CM/48/21/RES

Land to the West of Church Lane South of Horsemere Green Lane Climping

Approval of reserved matters following the grant of CM/1/17/OUT for the erection of 300 No dwellings & a building within use class E, together with public open space, LAPs, LEAP & ancillary works, including car parking & drainage arrangements, with access off Church Lane & Horsemere Green Lane. This application may affect the setting of listed buildings & is in CIL Zone 4 (HSP2) & is not CIL Liable

Additional Comments:

Revision N
Project Land at Climping Littlehampton
Title Site Plan
Dwg# 20.050.02
Status Planning

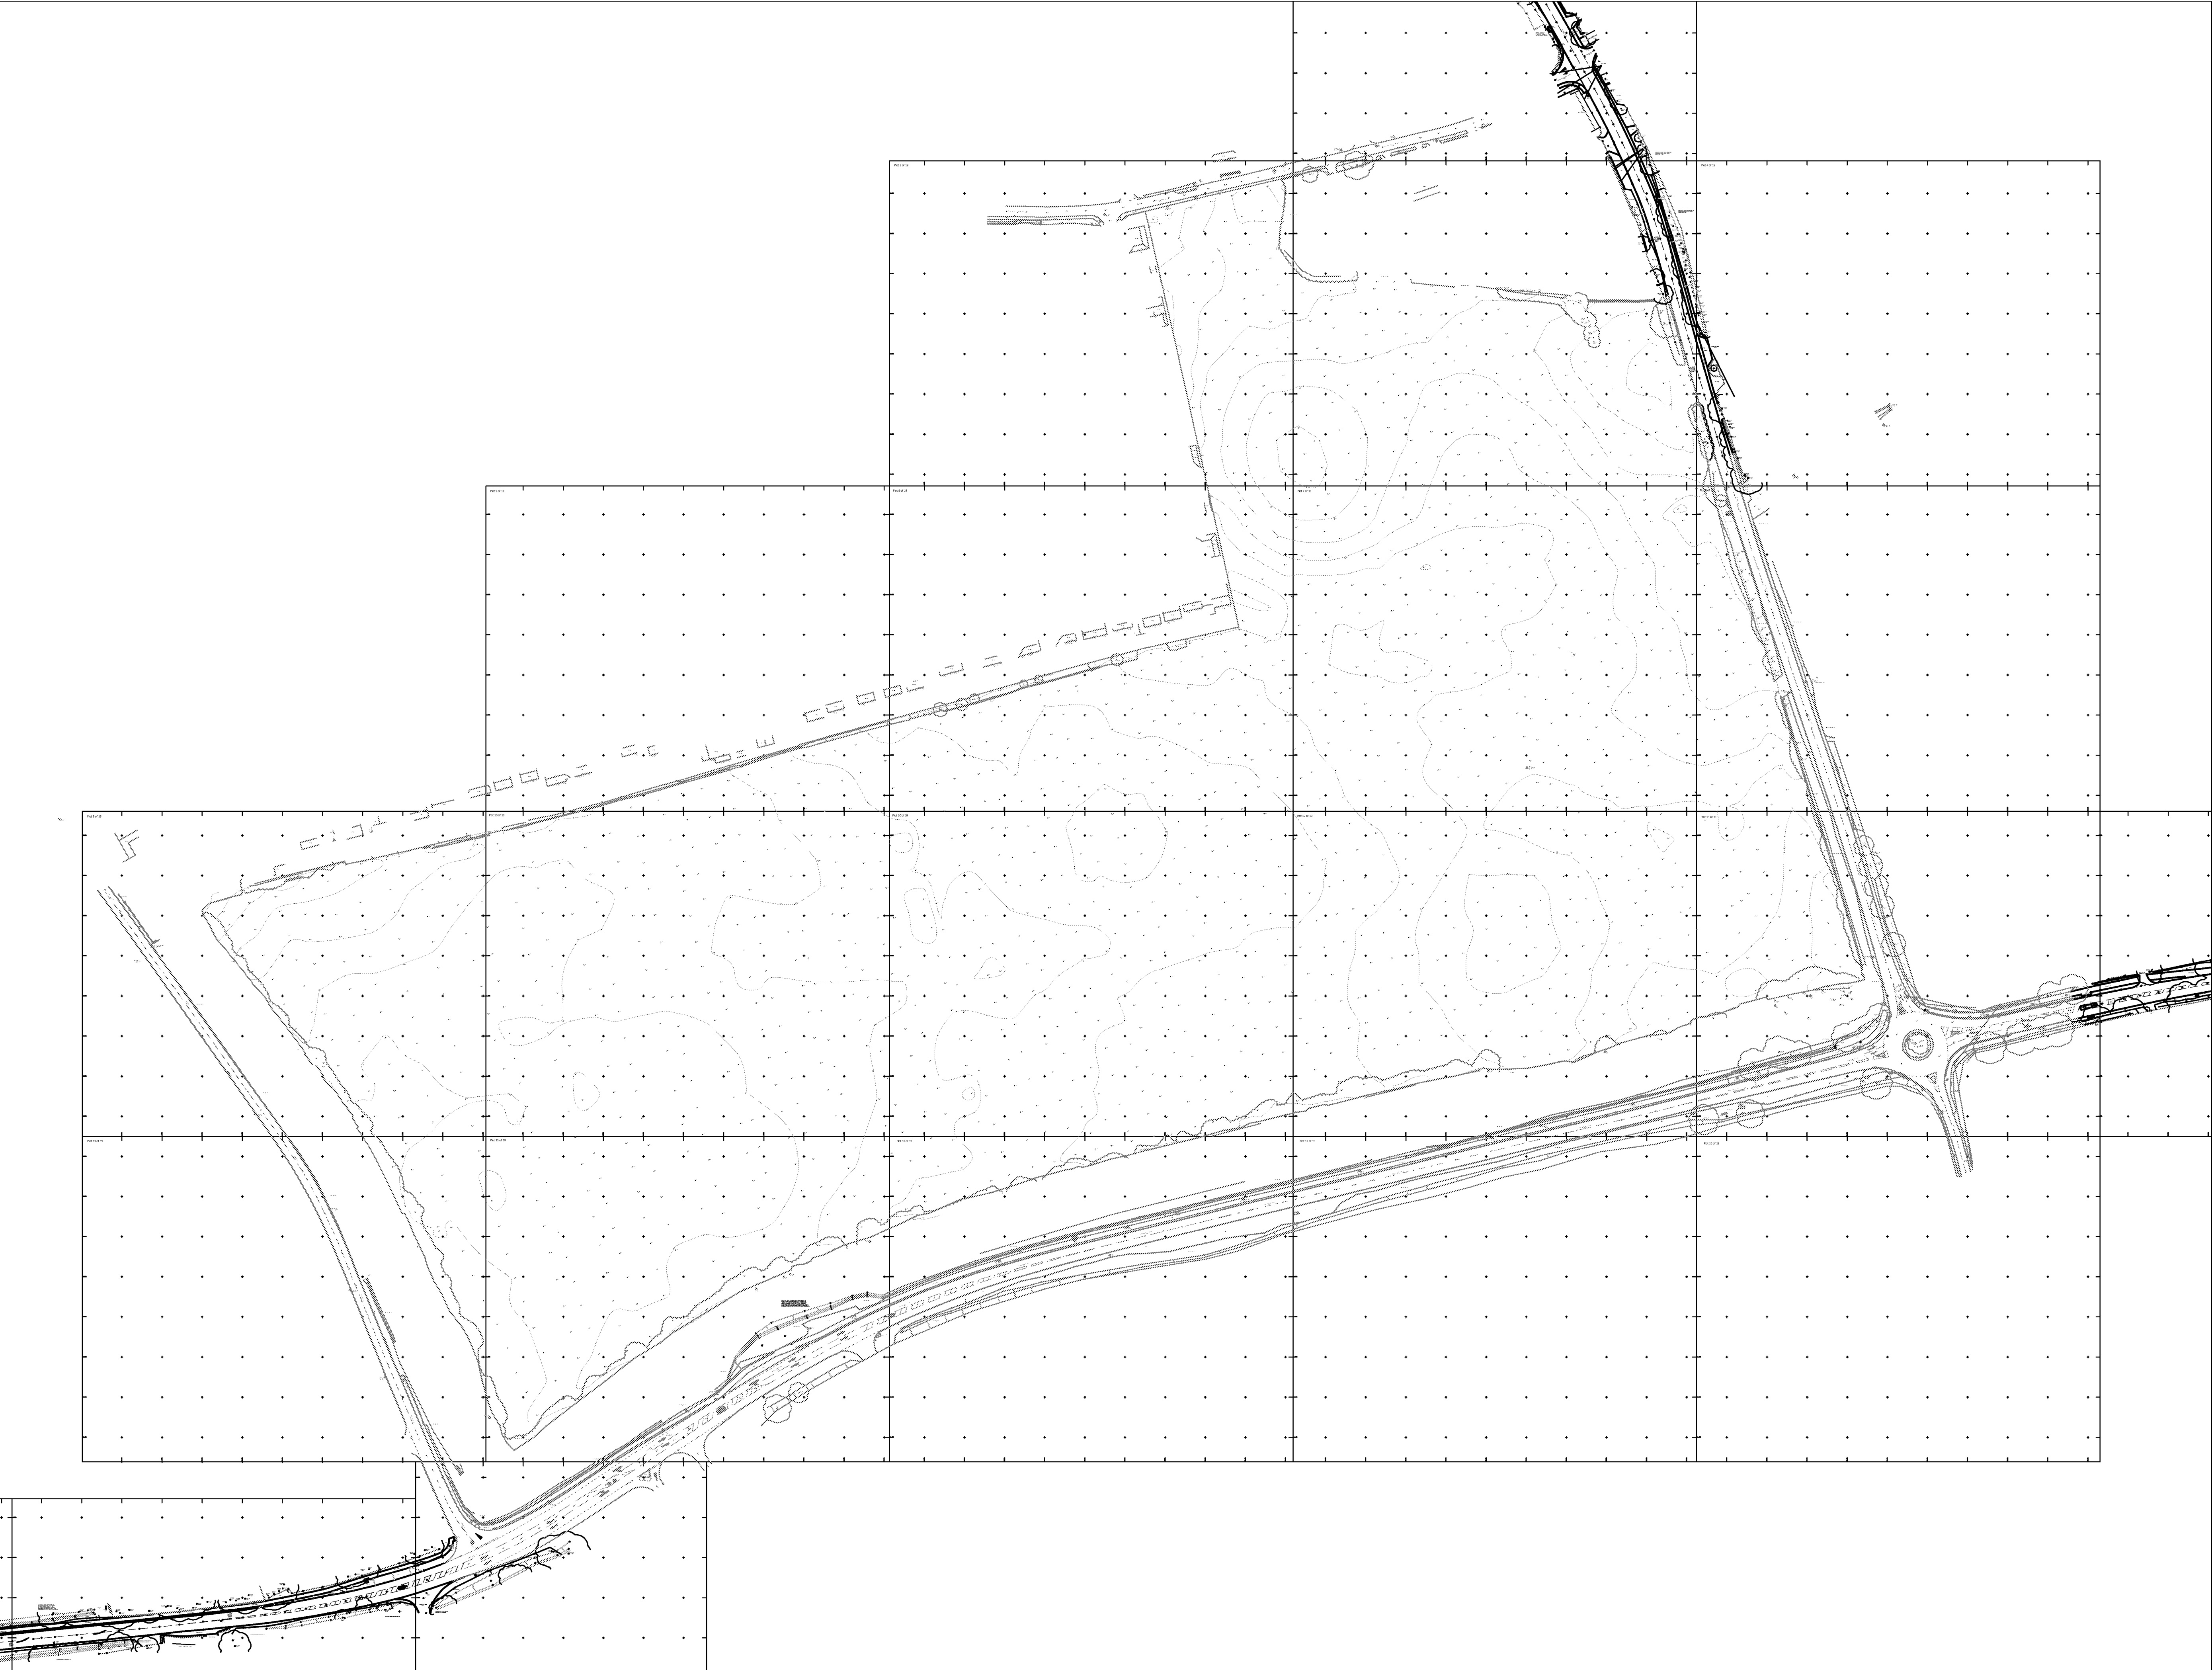
I note that the site plan indicates that there will be a buffer area between the new houses in the northern/north-eastern part of the site and the existing buildings (including the listed buildings) that forms part of the historic core of the village. This buffer includes proposed trees/shrubs and basin areas (or SUDS).

However, as noted with the previous plans (provided as part of this application), this buffer area has been greatly reduced in size from that identified in the outline application. The current plans show what appears to be two limited areas of additional screen planting and a reduced grassed area. Whereas the previous buffer provided enough space for the new development to be adequately set back from the historic core so that the area around it could be appreciated. As currently prepared, these limited buffer areas result in the built development encroaching much closer to the historic core, which will reduce the impact that the buffer will have, which is disappointing and potentially harmful.
